**BEFORE the HEARING EXAMINER for the
CITY of MERCER ISLAND**

DECISION

FILE NUMBERS: CAO15-001 & VAR18-002

TYPE OF CASE: Consolidated: 1) Critical Areas Reasonable Use Exception to construct a single-family residence and associated improvements within a regulated wetland and required wetland and stream buffers; and 2) Variance from the setback requirement from an access easement

- SLOPE
- WETLAND
- STREAM & BUFFER

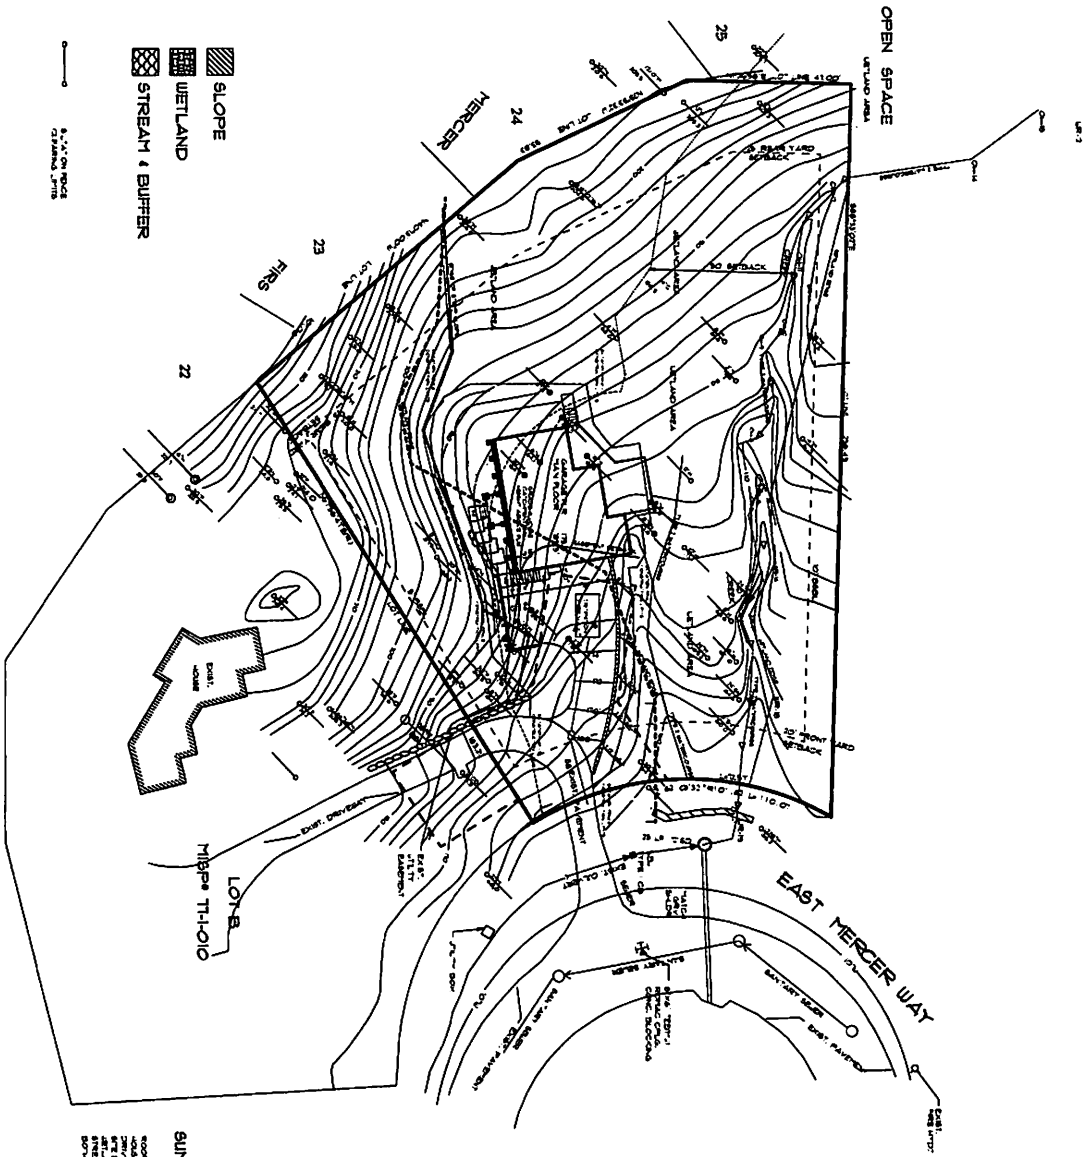
⁶ The west property line segment call-out lengths on the currently proposed site plan (Exhibit 38) match the call-out segment lengths on the original short plat that created Parcel 9312 (Exhibit 39). However, the line segments as drafted on Exhibit 38 do not match the call-out lengths: The north segment which should be 47 feet is drawn as 57 feet; the middle segment which should be 94 feet is drawn as 65 feet; and the south segment which should be 101 feet is drawn as 119 feet. The total length is about the same, but the segment lengths and resulting angles are inaccurate. Thus, it appears that Parcel 9312’s shape is inaccurately presented on Exhibit 38.

Neither the off-site northern or western steep slopes are depicted on the proposed site plan, Exhibit 38.

⁸ The inference from the contour lines on Exhibit 38 near the north property line that the parcel to the north exhibits gentle slopes is most likely quite mis-leading. Exhibit 23, Appendix A, PDF pp. 6 & 7 strongly suggests that the slope becomes significantly steeper immediately to the north.

15. Stream B is depicted in various locations and with various lengths on the maps and plans contained in the record. (Exhibits 12b, PDF pp. 3 & 20¹⁰; 12c, PDF p. 7; 38; 42d, PDF p. 5) On the latest project plan (Exhibit 38) Stream B defies geographical logic: It is depicted as flowing diagonally down the shallow side wall of a small, on-site draw. Streams simply do not do that in the real world.¹¹ Streams flow down the centerline of draws or ravines, not slaunchwise down their sides. If the topography on Exhibit 38 is accurate and if Stream B were properly mapped, it would originate at or flow beneath the northeast corner of the proposed residence, depending on its length. By drawing Stream B on the side of the slope, it misses the house by about seven feet. (Exhibit 38)

The short plat contains two easements for access and utilities, one shared by Lots A & B (the Stivelman Lot), the other shared by Lots C & D. The easement shared by Lots A & B can best be described as roughly “Y” shaped, with the base of the “Y” abutting East Mercer Way. The base of the “Y” is about 45 feet wide; it is almost 32 feet long on its north side but only 7 feet long on its south side.¹³ The north arm is 30 feet wide and 41 feet long. The south arm is 32 feet wide and 31 feet long. The base and the north arm are wholly located within Lot A; the south arm is wholly located within Lot B. (Exhibit 39) This access and utility easement is depicted on Exhibit 38.
